**NW BICESTER
25 FEBRUARY 2016 – MEETING NOTE**

5.0	CONDITIONS 18, 24, 29, 31 AND 33 (INFRASTRUCTURE)
	<p>Primary Road General Arrangement 1 of 6</p> <p>5.1 RJ advised that CDC required 1.8m clearance. RJ requested a mix of tree types along the boulevard. Hornbeam is susceptible to disease, would be problematic for residents and is uninteresting.</p> <p>5.2 TG advised Hornbeam had a lower water requirement. BP advised CDC that Arcadis had used Hornbeam successfully elsewhere. The team expressed concern about late comments on tree species.</p> <p>5.3 The principle of the tree locations/ types has been established in the Section 38 Agreement with Oxfordshire County Council.</p> <p>5.4 RJ advised in that case, he would accept what was proposed, however, would prefer a species mix (thirty percent diversity) and considers the tree type to be the incorrect species.</p> <p>5.5 TS advised he considered the propose ground cover shrubs (Liriope Muscari and Bergenia Cordifolia) would become an eye sore over time. TG advised that A2Dominion would manage and monitor the ground cover shrubs. If amendments are required, these would be undertaken in the future. CDC accepted this. TS reiterated th

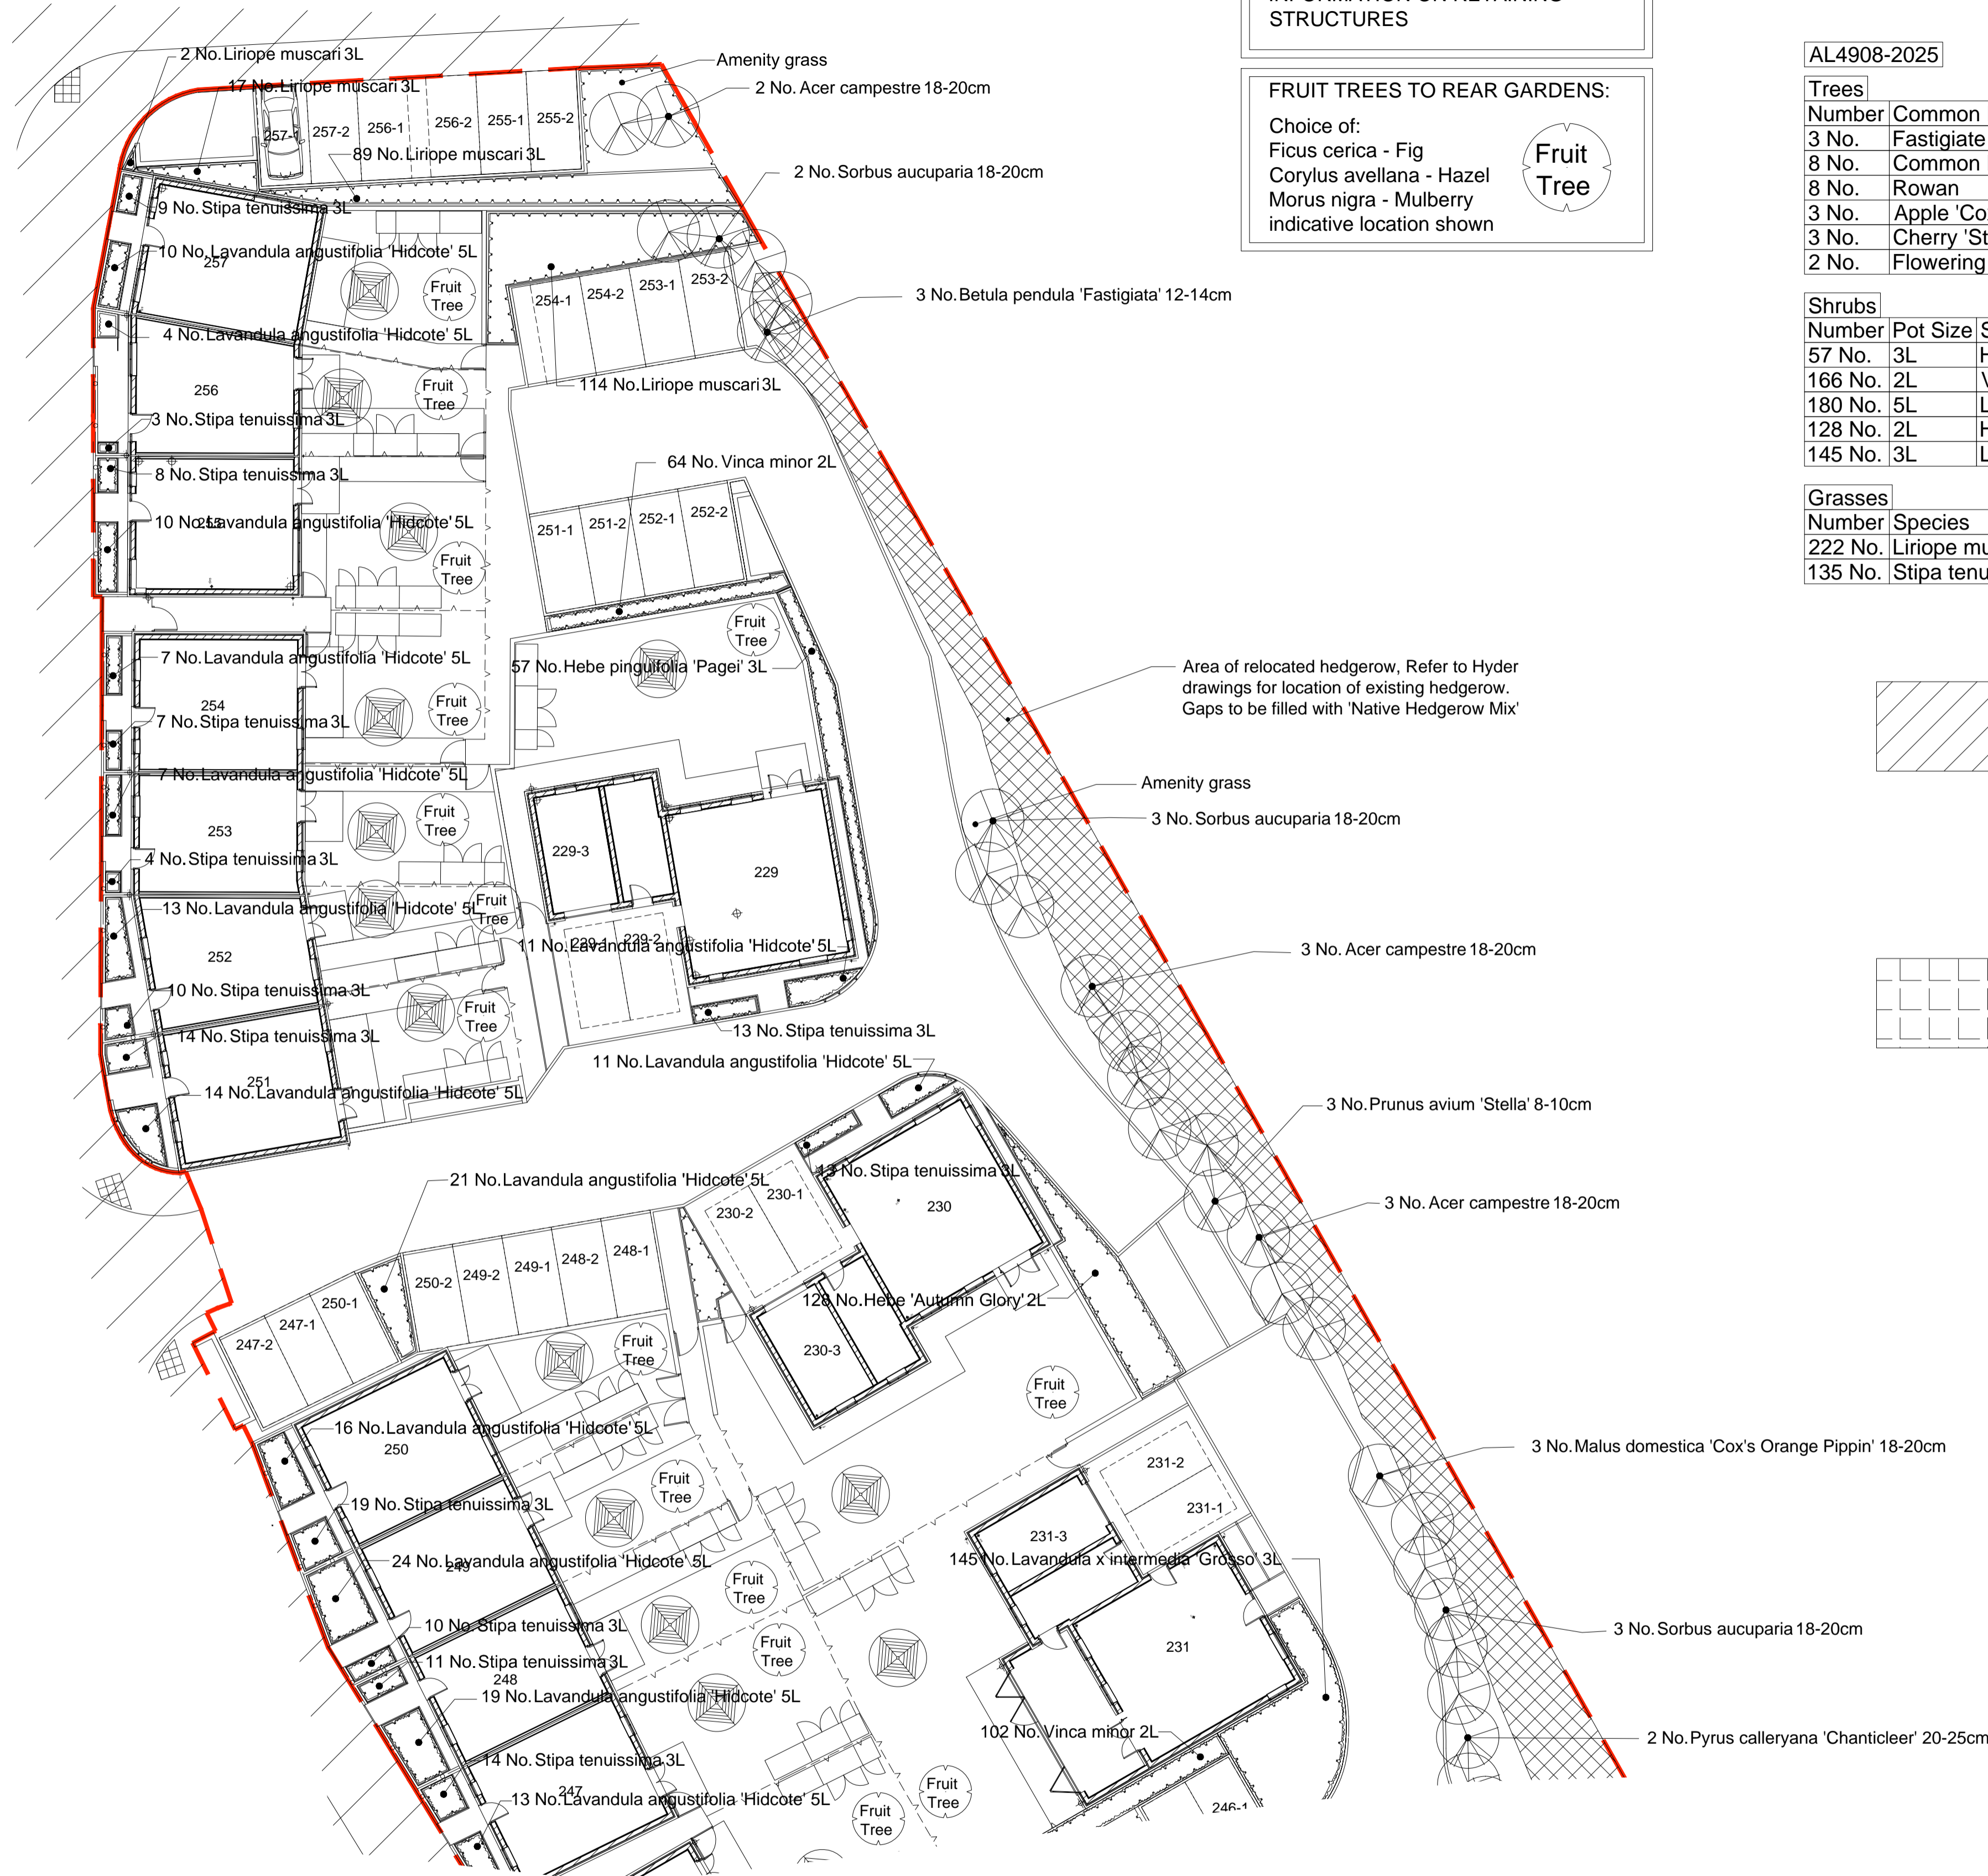
- 6.11 It was agreed that Sorbus Aria at the frontage of plots 329, 330, 337, 338 and 339 would be removed and replaced with Amelanchier Lamarkii.
- 6.12 It was agreed that Acre Campestre 'Streetwise' at the front of plots 340 to 341 would be replaced with a mix of Betula Pendula and Amelanchier Lamarkii.

- 6.13 It was agreed that the Prunus 'Sunburst' south of plot 309 would be substituted for an alternative species (moving away from Prunus). Arcadis and A2Dominion to consider.

- 6.14 RJ advised that he wanted to avoid over shading near parking bays 301-1 and 305-1. He asked that one tree is provided either side (rather than two). RJ suggested Birch in these locations. Arcadis and A2Dominion to consider.

- 6.15 Near parking bays 303-2 and 304-1, RJ requested that the species was swapped to a birch/ keep three in. This applies to the other side also (thirty percent diversity). Arcadis and A2Dominion to consider.

- 6.16 In relation to walls adjacent to lot 371, RJ requested that White Beam is avoided. Something with greater illumination should be provided. Arcadis and A2Dominion to consider.

- Hedges**
- 6.17 It was agreed that Arcadis/ A2Dominion would consider an alternative hedge species near plot 315 (potentially Holly or Hazel).

- 6.18 It was agreed that the Carpinus Betulus hedge to the south of plot 308 would remain double.
 - 6.19 It was agreed that the Carpinus Betulus hedges near building foundations and walls would be switched to an alternative species. A2Dominion and Arcadis to consider.
